Your ref: SSD 10399
File no MC-20-00009

SSD 10399 – Clunies Ross Street, Prospect

Blacktown Council's submission to SSD 10399

DRAWING TITLE	
CONCEPT STORMWATER DRAINAGE	
PLAN	
SHEET 1	
DRAWING No	ISSUE
C013251.06-DA41	E

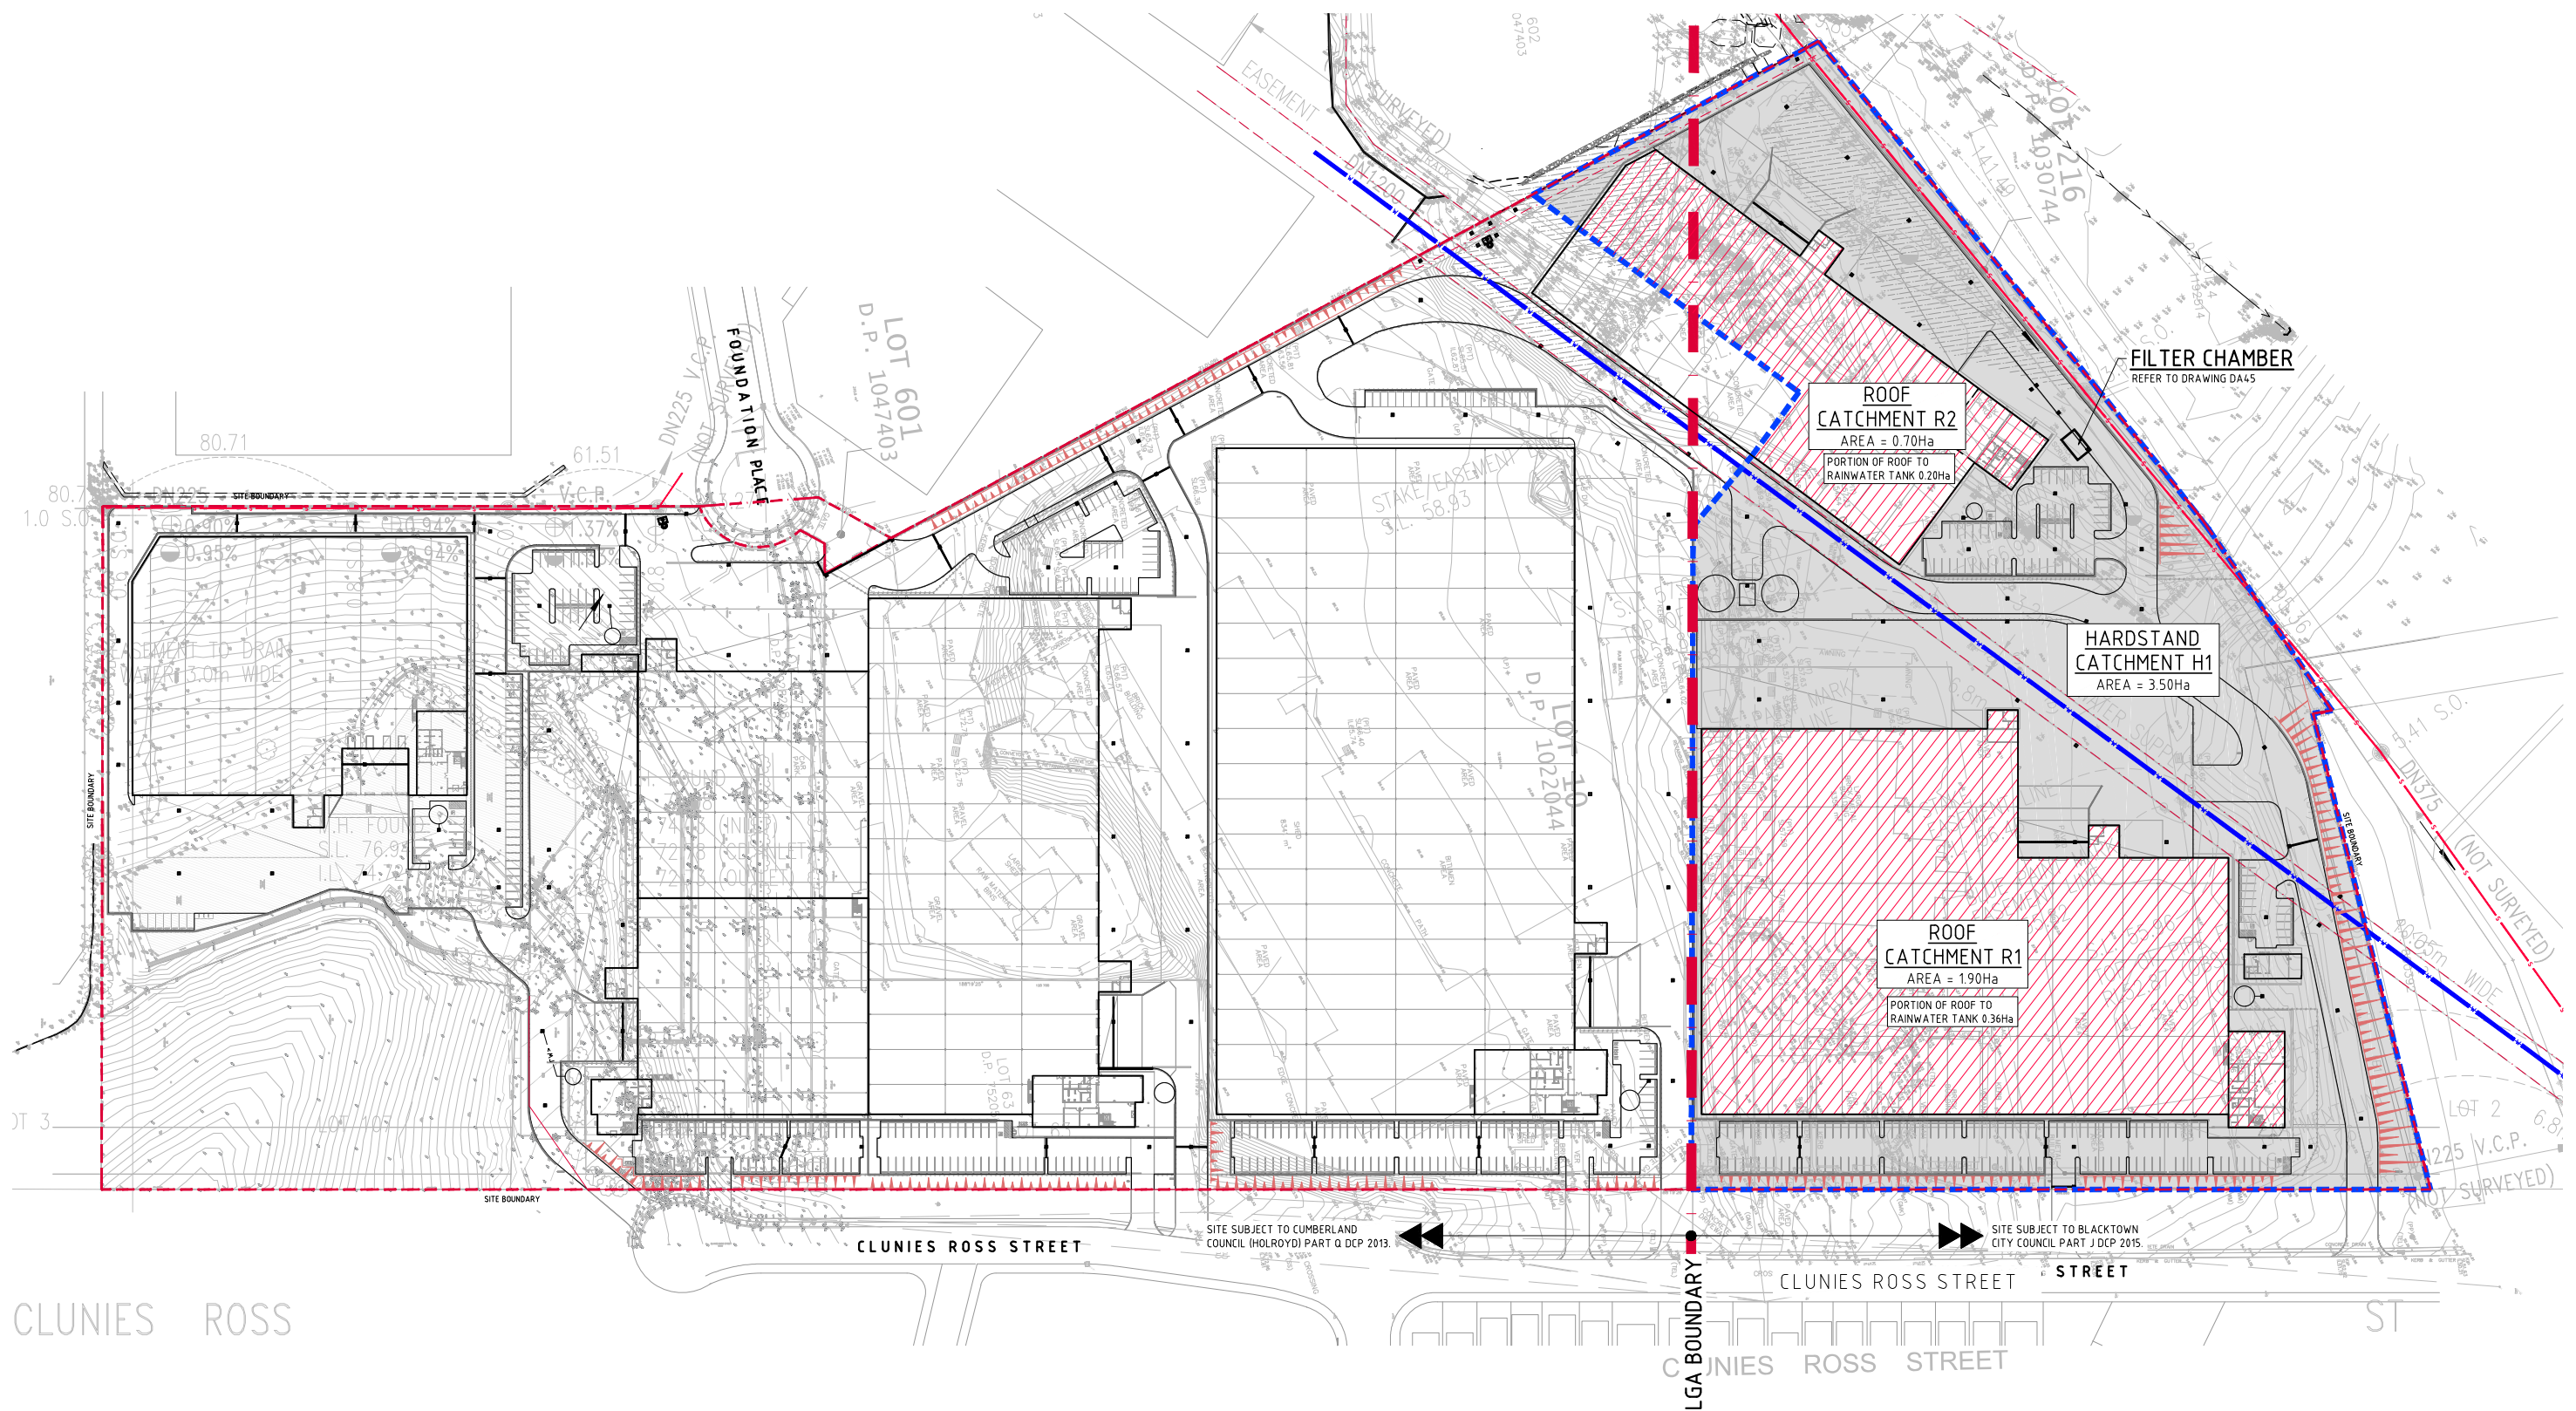
- Clarity is required in relation to the combined area of the site. The response letter by Costin Roe Consulting (dated 8 December 2020) confirms the development site area to be 18.66 hectares, however no changes have been made to the engineering plans and MUSIC models. Drawing DA40(D) of the engineering plans (dated 9 December 2020) and MUSIC models depict a total area of 17.59 hectares. All areas, including the Aboriginal Heritage area, is to be included in the MUSIC models.

BASIN WORKS PLAN
SCALE 1:500

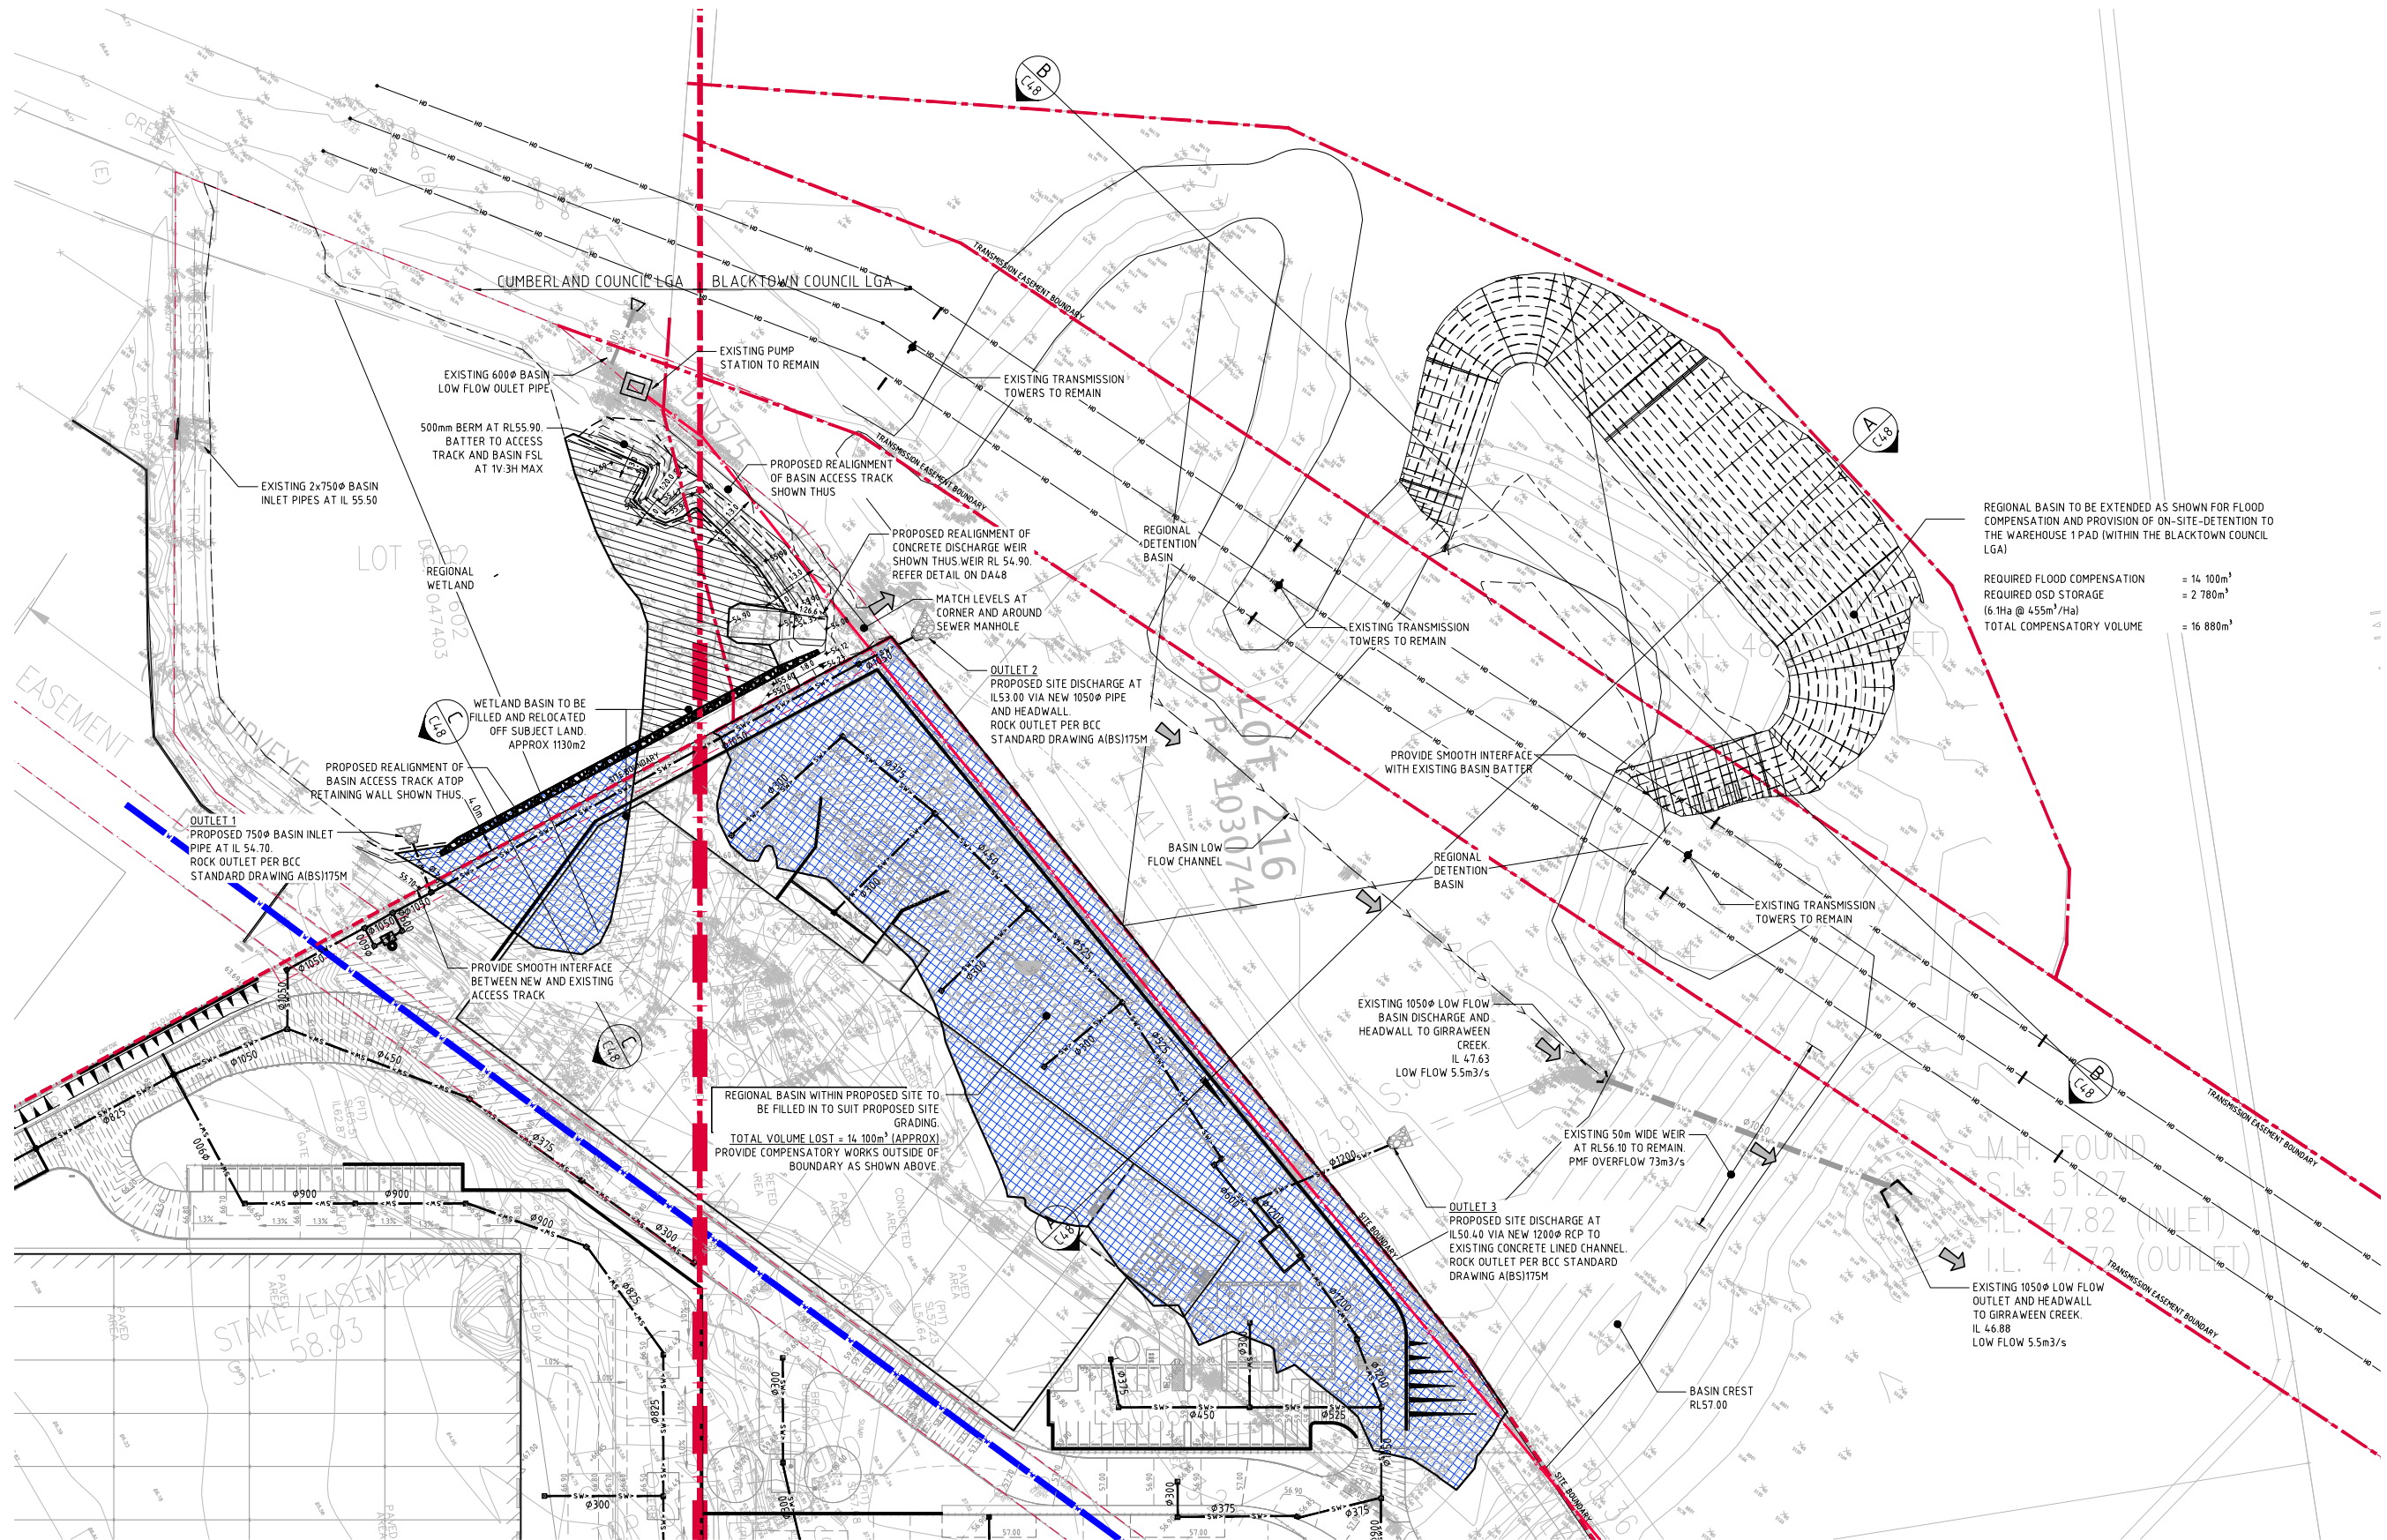
- On drawing Co13251.0-DA44, show the impervious area in % adopted for each catchment in the hydrology model.
- On drawing Co13251.0-DA45:
 - The Stormfilter tank is to include a baffle 400 mm below the Stormfilter weir and set 250 mm upstream from the weir to retain floatables including oils for the 690 mm cartridges.

- Provide metal mosquito proof mesh welded over the access grate(s) into the Stormfilter Chamber.
 - Provide an energy dissipater for each inlet pipe into the filter storage chamber. The dissipaters are to be clearly labelled (i.e., provide notes).

- There are insufficient access points for the below ground Stormfilter chamber. Access points must be a minimum 900 mm by 900 mm and are positioned such that the maximum distance from any point in the tank to the nearest access is not greater than 2 m. Attach metal mosquito screens under where there are grates.

- The weir height is to be 770 mm + false floor thickness.
 - The DCP grates above the overflow pit are to be 1200 x 1200.
 - Provide galvanised equivalent step irons or ladders at 300 cts for all entry points to the tanks.

- The minimum length of the Stormfilter weir (L) is to be increased to provide a maximum velocity of 0.4 m/s under the baffle during peak flow (i.e. $L > Q_{20} / (0.4 \times 0.25)$, or $L > 10 \times Q_{20}$ in m, where Q_{20} is in m³/s). Provide calculations.
